From: Adam Cooper [REDACTED]
Sent: 12 March 2013 16:16
To: Charlotte Burrows
Subject: RE: EG/68/12 - 73 Elm Grove

I applied for a non material amendment for the inclusion of two Velux windows.

**PROPOSED ROOF PLAN**  
(1:100)

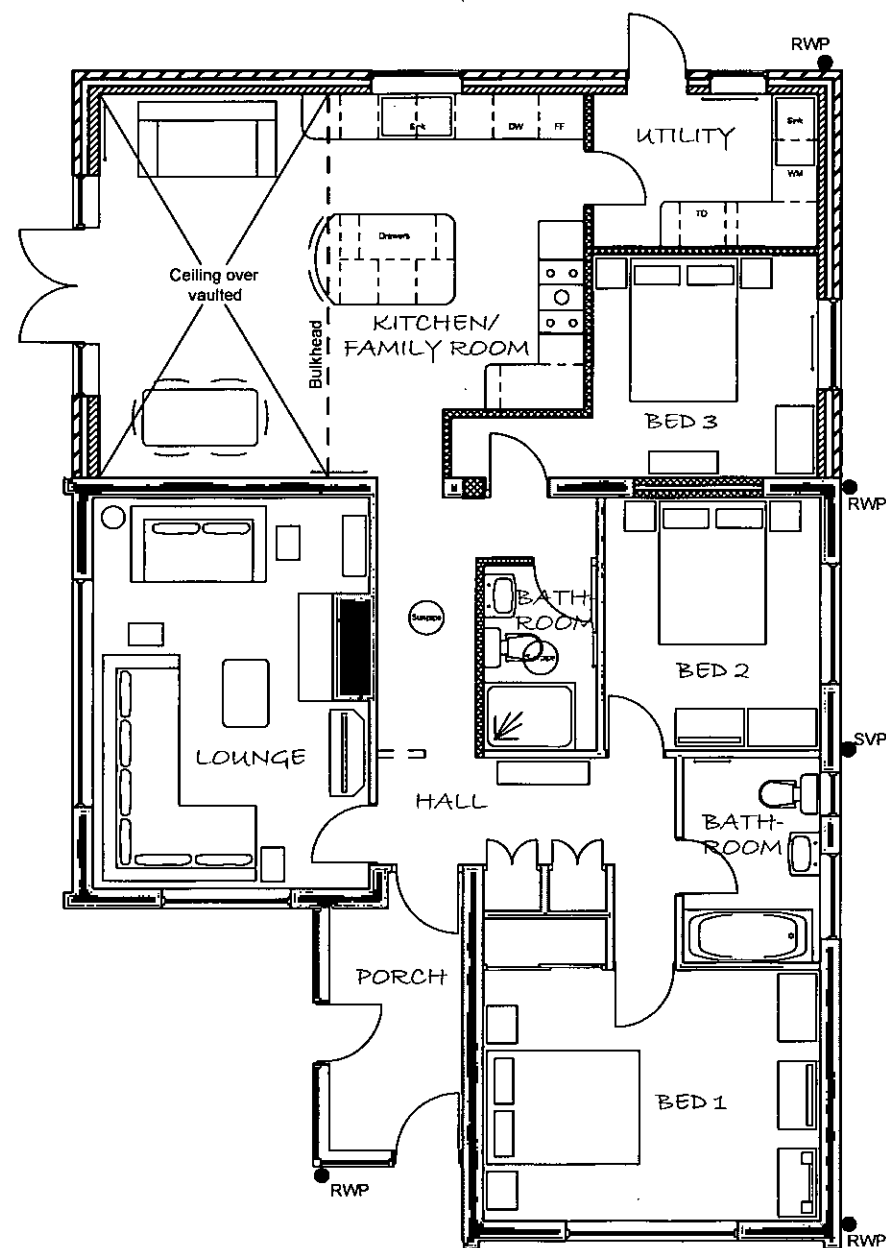
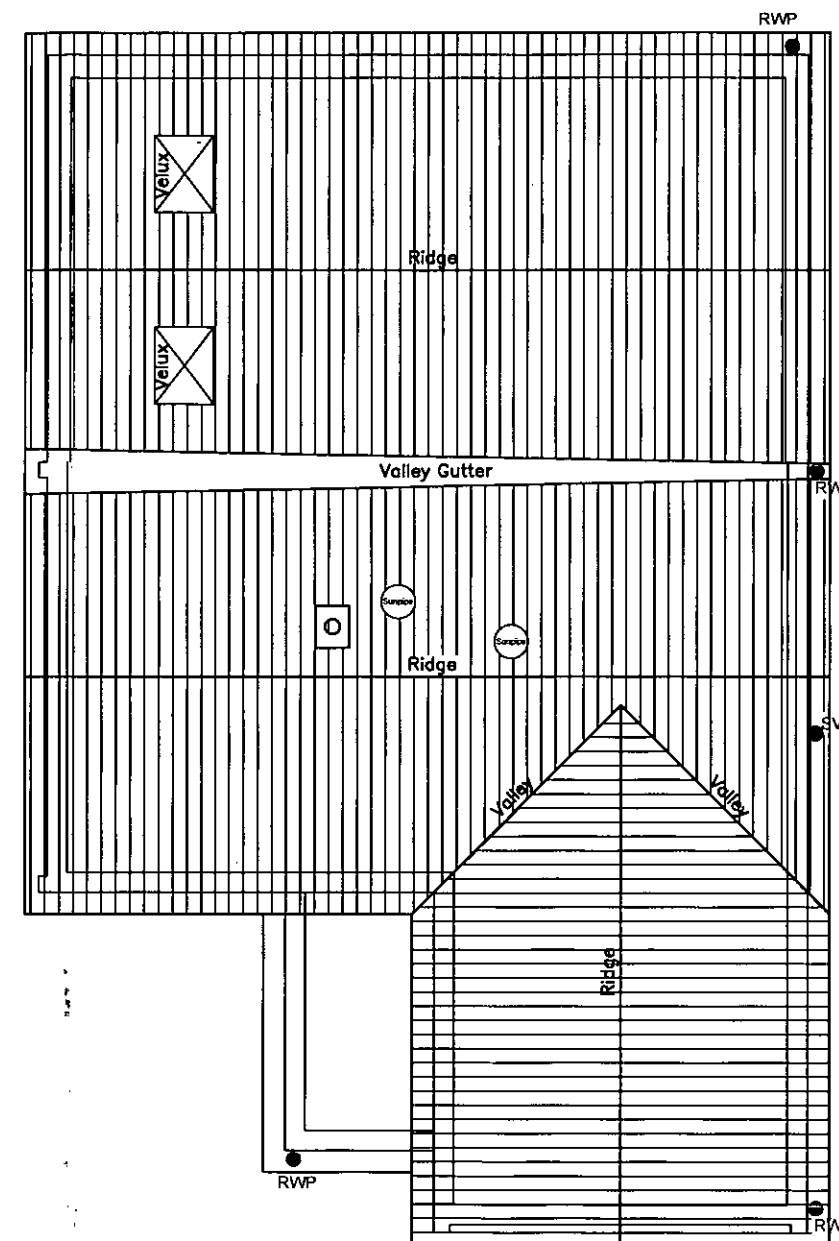
The approved roof plan was revised to indicate both Velux windows and the approved rear elevation was revised to indicate one of the Velux windows.

Regarding the conversation we had on Friday relating to the Non material amendment application you have submitted, I have spoken to Mrs Chapman regarding you showing both velux windows on the elevation plans and after you explained I can see this would be problematic. Therefore could you please just confirm in writing that this is the case and that you are unable to draw the second velux on the elevation and explain why. A response to this email would be acceptable.

The second Velux window does not appear on any of the approved elevations as it is on the valley side of the extension (hidden from view). Therefore it has not been shown.
